**Consultation Response from Mike Hibbert,
KC Waste Strategy(Refuse & Recycling)**
2024/91923 adj, 9a, High Street, Birstall, Batley, WF17 9ES
Discharge conditions 3-7, 9, 11, 12 on previous permission 2023/90918 for erection of detached dwelling (within a Conservation Area)
Date Responded: 16/07/2024.
Responding Officer: Mike Hibbert
Responding Ref: WPN 24-018

These comments relate to the discharge of Conditions 7 that states: -

Revision History			
Rev/ID	Ch/d	Change Name	Date
Proposed New Build Bungalow 9A High Street Birstall WF17 9ES			
PROPOSED SITE PLAN - 1:200			
Drawing Status PLANNING APPLICATION			
Modified by TT		Date July 2024	
Checked by TT		Date July 2024	
Drawing Scale at A1 1:200		Revision -

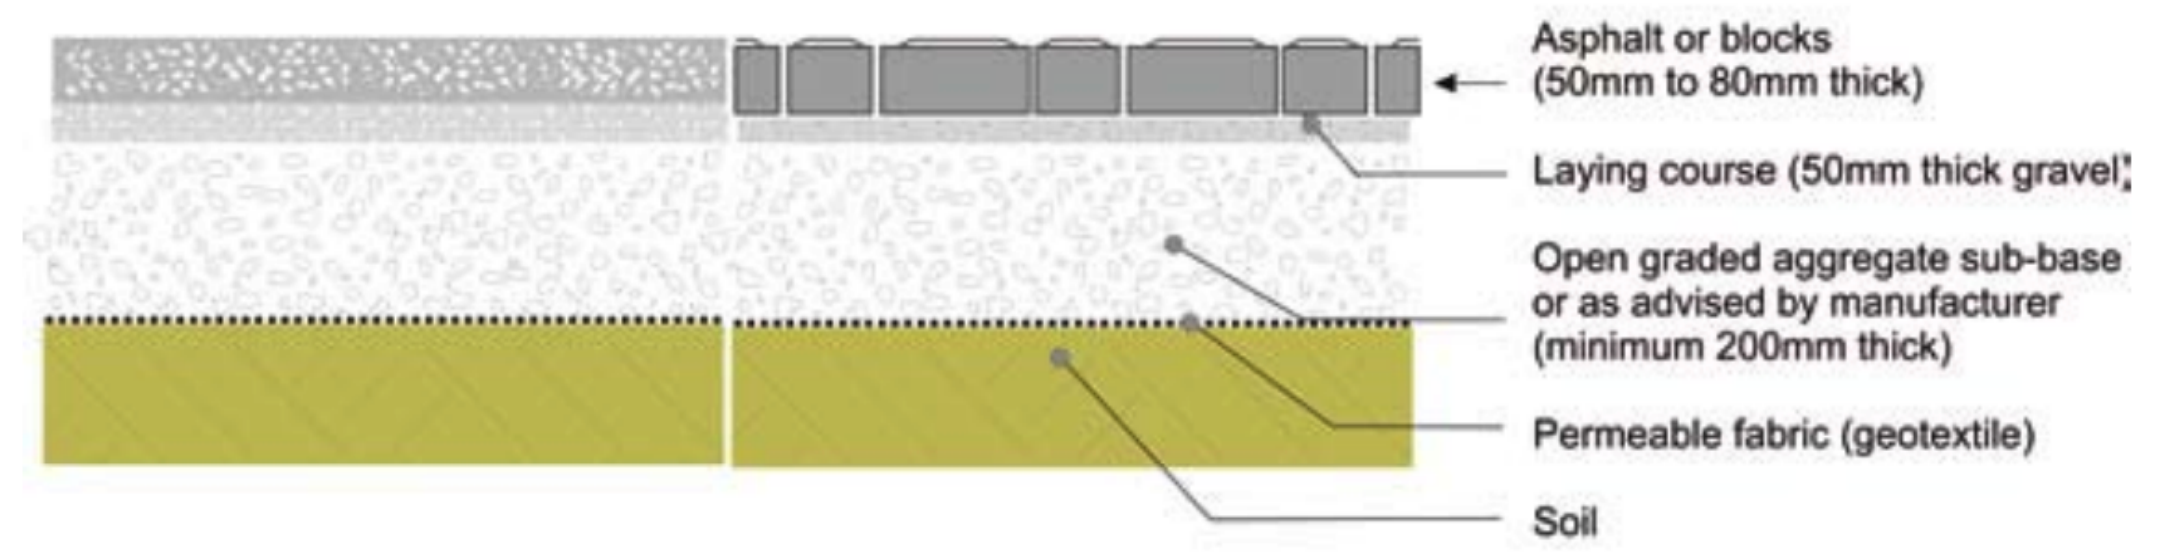
The applicant has submitted PROPOSED SITE PLAN Ref Layout ID (PL) 002 dated July 2024. This is annotated to show the location of bin storage and a Bin Collection Point (BCP)

- There is a preference for bin storage in the rear garden of properties to avoid an impact on Streetscene and this would be achievable within the curtilage of the dwelling.
- The Bin Collection Point (BCP) is acceptable if it avoids presentation of bins on the highway/pavement and doesn't impact on the access to dwelling 9a.

The WCA does not have an objection to Discharge of Condition 7.
